WEST SUSSEX COUNTY COUNCIL CONSULTATION

TO:	Arun District Council FAO: Ms Myer
FROM:	WSCC - Highways Authority
DATE:	5 July 2021
LOCATION:	Norton Farm House Norton Lane Chichester PO20 3NH
SUBJECT:	AL/86/21/L Listed building consent for the subdivision of existing building to create 2 bedroom dwelling, construction of detached garage/workshop, external & boundary works.
DATE OF SITE VISIT:	n/a
RECOMMENDATION:	Advice
S106 CONTRIBUTION TOTAL:	n/a

SITE PLAN

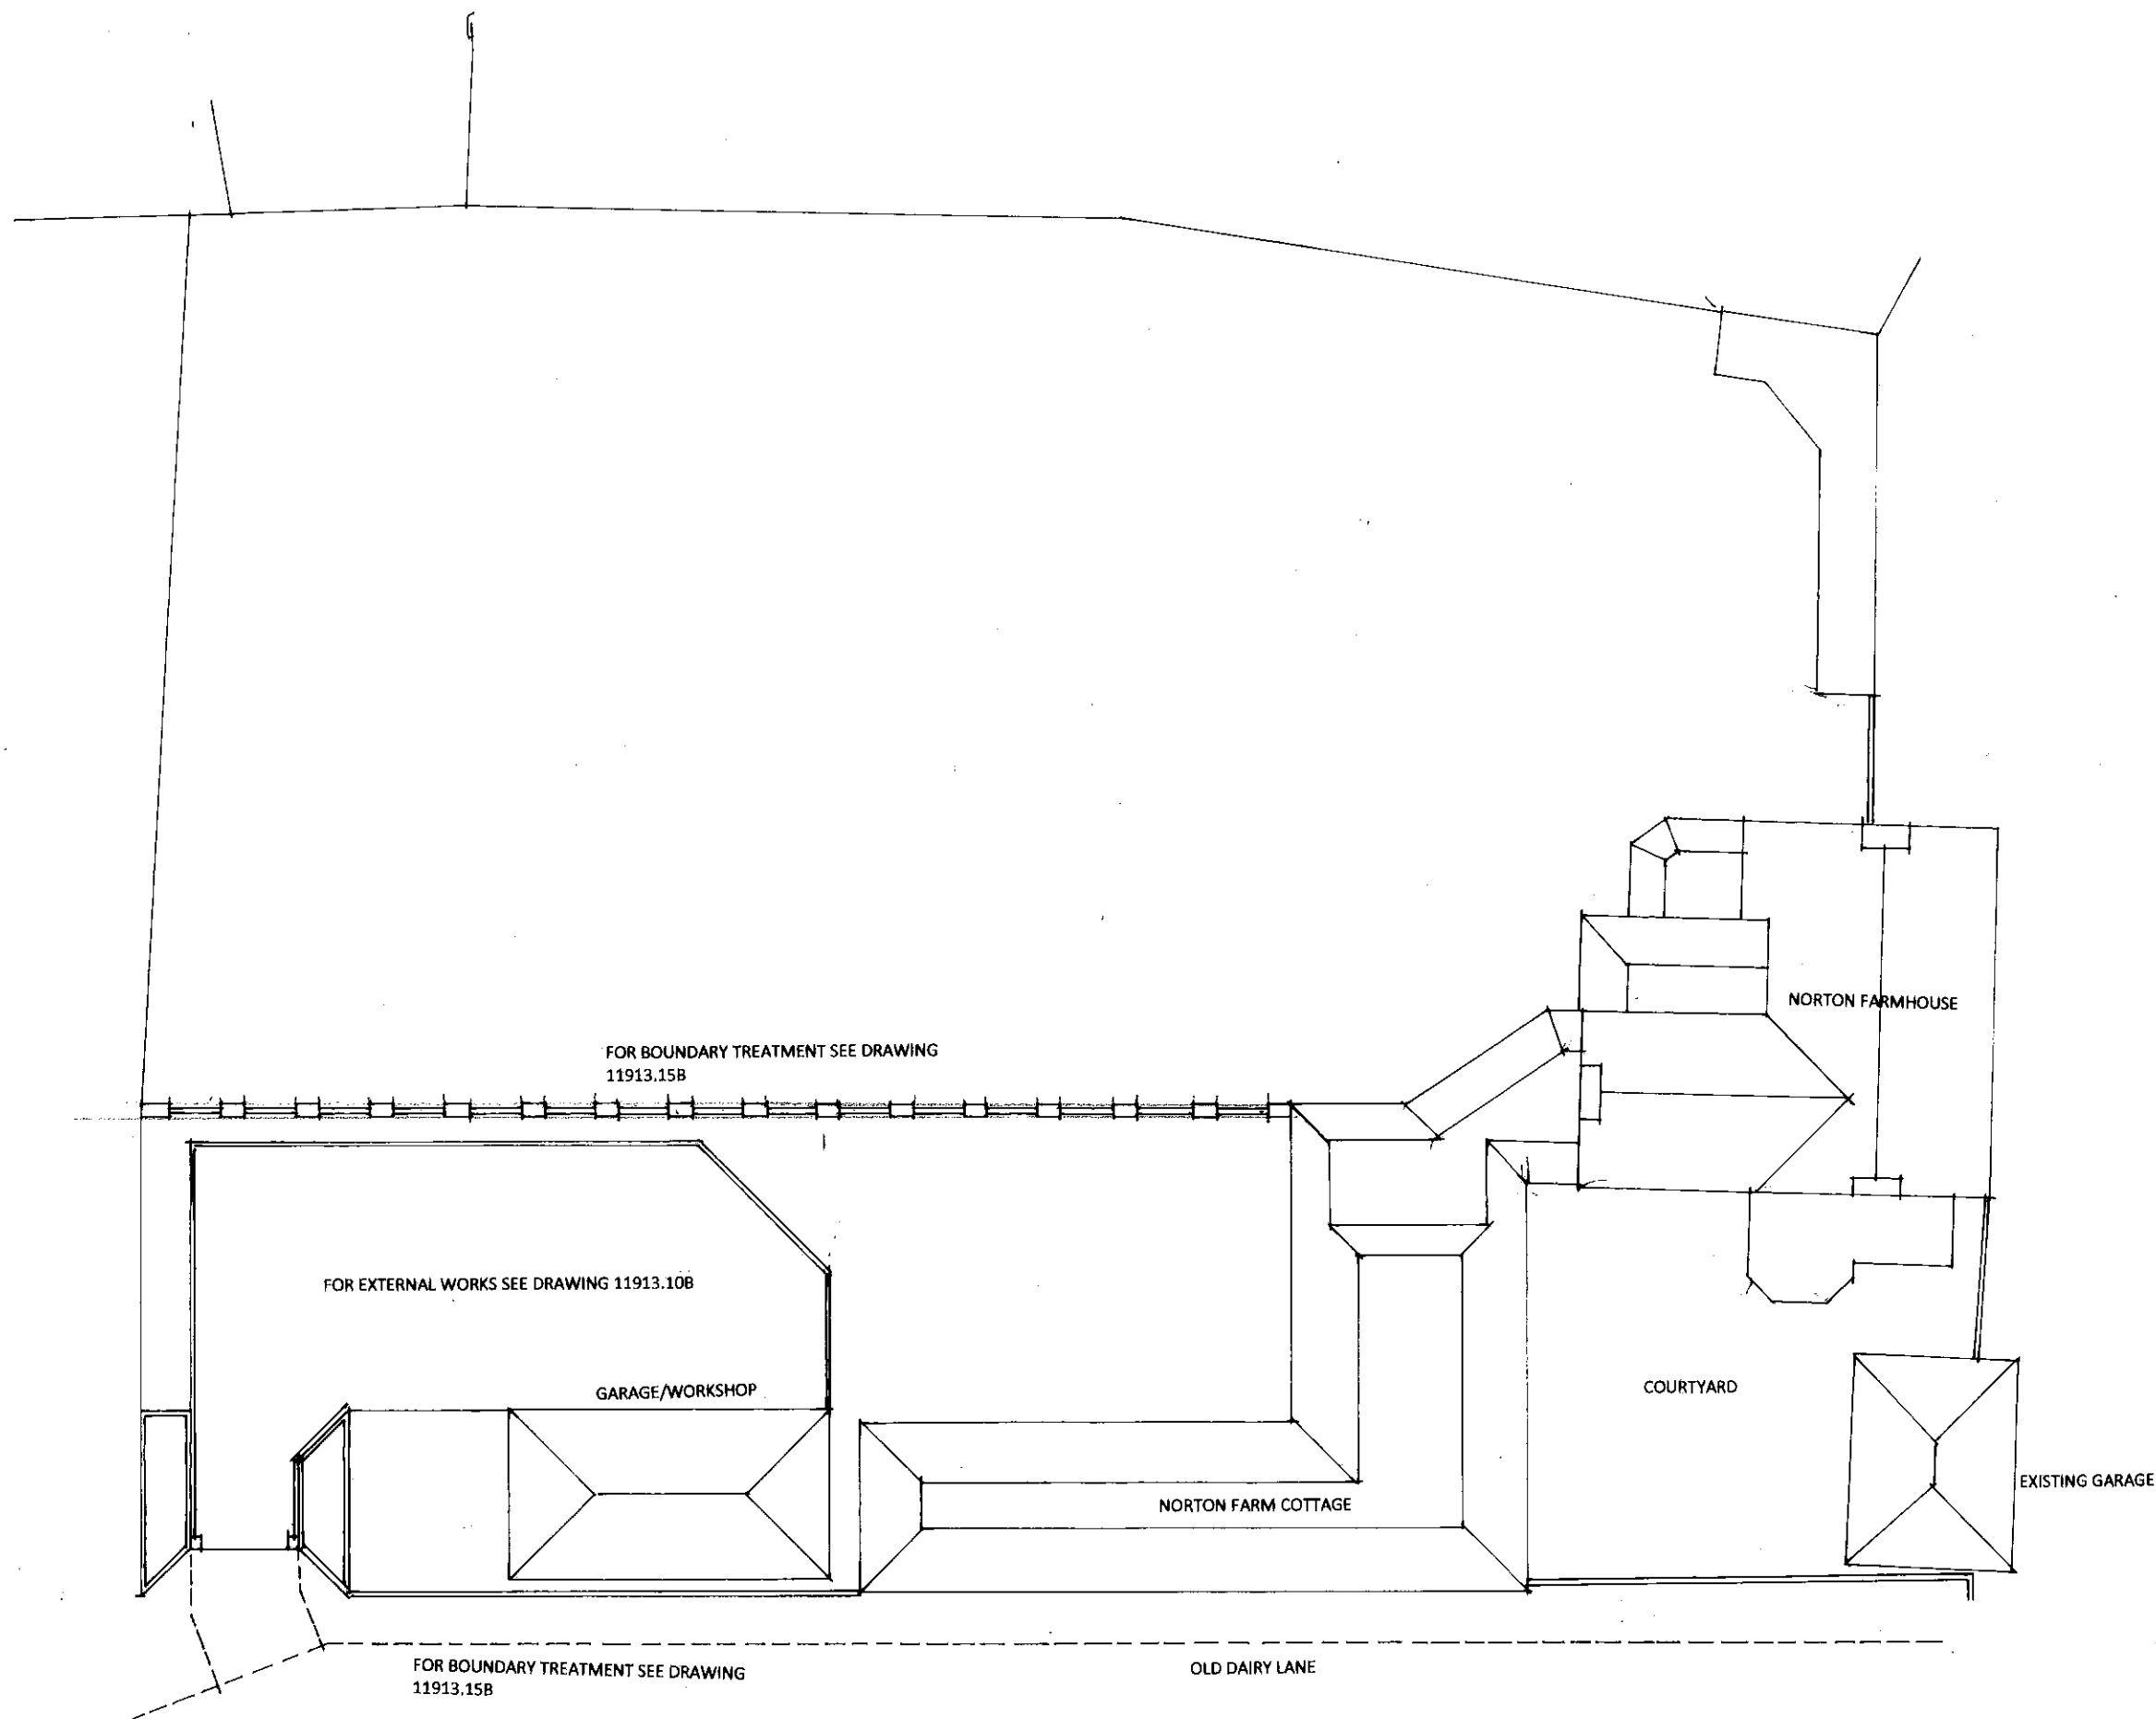
Suitable on-site parking provision is proposed for a dwelling of this size in this location. Cycle parking can take place within the garage facility.

No part of the development shall be first occupied until the car parking has been constructed in accordance with the approved site plan. These spaces shall thereafter be retained at all times for their designated purpose.
